Allison R Shriner
181 Sunset Rd.
Ellensburg, WA 98926

Kittitas County Community Development Services
Attn: Kelly Bacon
205 W, 5th Ave.
Ellensburg, WA 98926-2887
kelly.bacon.cd@co.kittitas.wa.us, 509 962-7539

As a past resident of the Parke Creek area for thirty years, along with immediate family residing in the area (mother, father, brothers), it has come to my attention that Brown & Jackson, Inc. has plans of building and operating two septage ponds at the mouth of Parke Creek Canyon. After perusing the SEPA Application, the Addendum, and the Grading Permit, there are some components of this plan that I would like to address.

SHEET NO. C1.2
201834

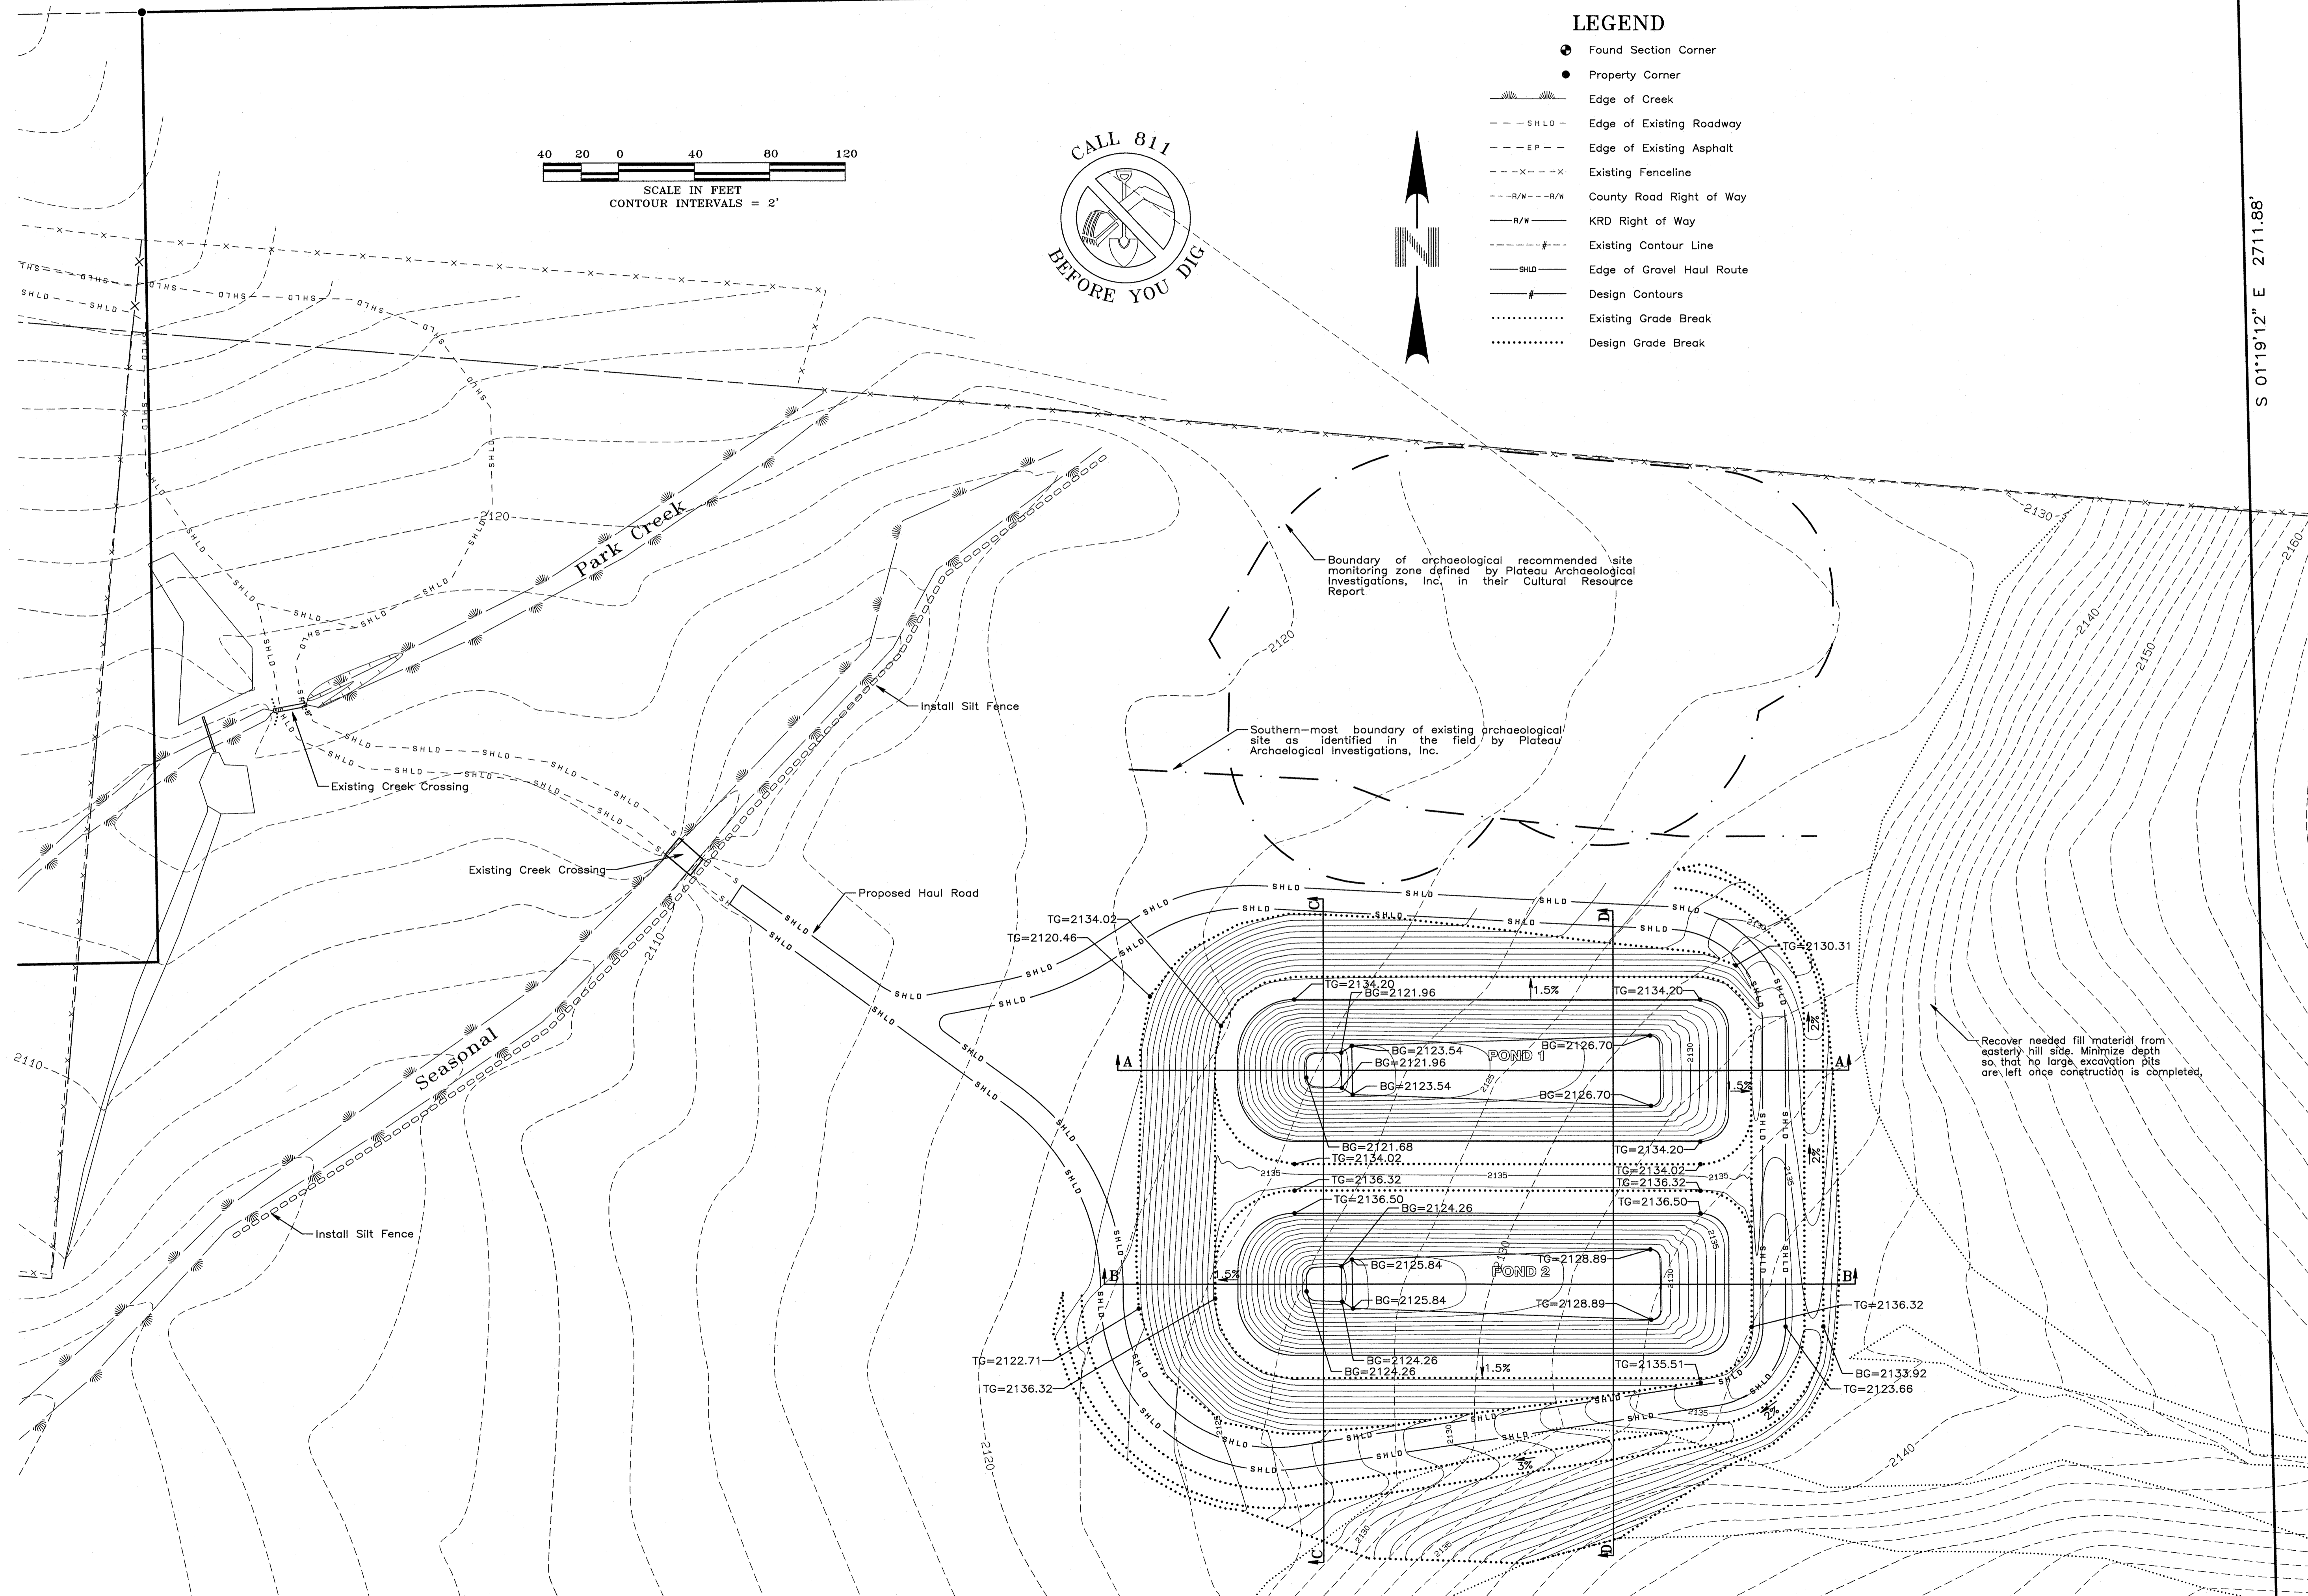
2) The plan states that there should be no expected runoff of waste materials into the ground or surface water. However, **if a leak occurs in the lining of one or both of the ponds**, the effluent will run down or be absorbed into the creek bed due to their location 10 feet above the lowest point. If the leak goes undetected for a protracted period of time, the effluent will enter the ground water, which could **contaminate well water** for people in the area who depend on their wells for drinking water. It could also adversely affect **people's fields that are irrigated by water from the creek and the ground water that people pump from their wells for irrigation**. In the letter, it is passively addressed that they will meet minimum requirements, but as seen with other similar sewage storage ponds – like in Sunnyside, it has had adverse impacts on the ground and surface water.
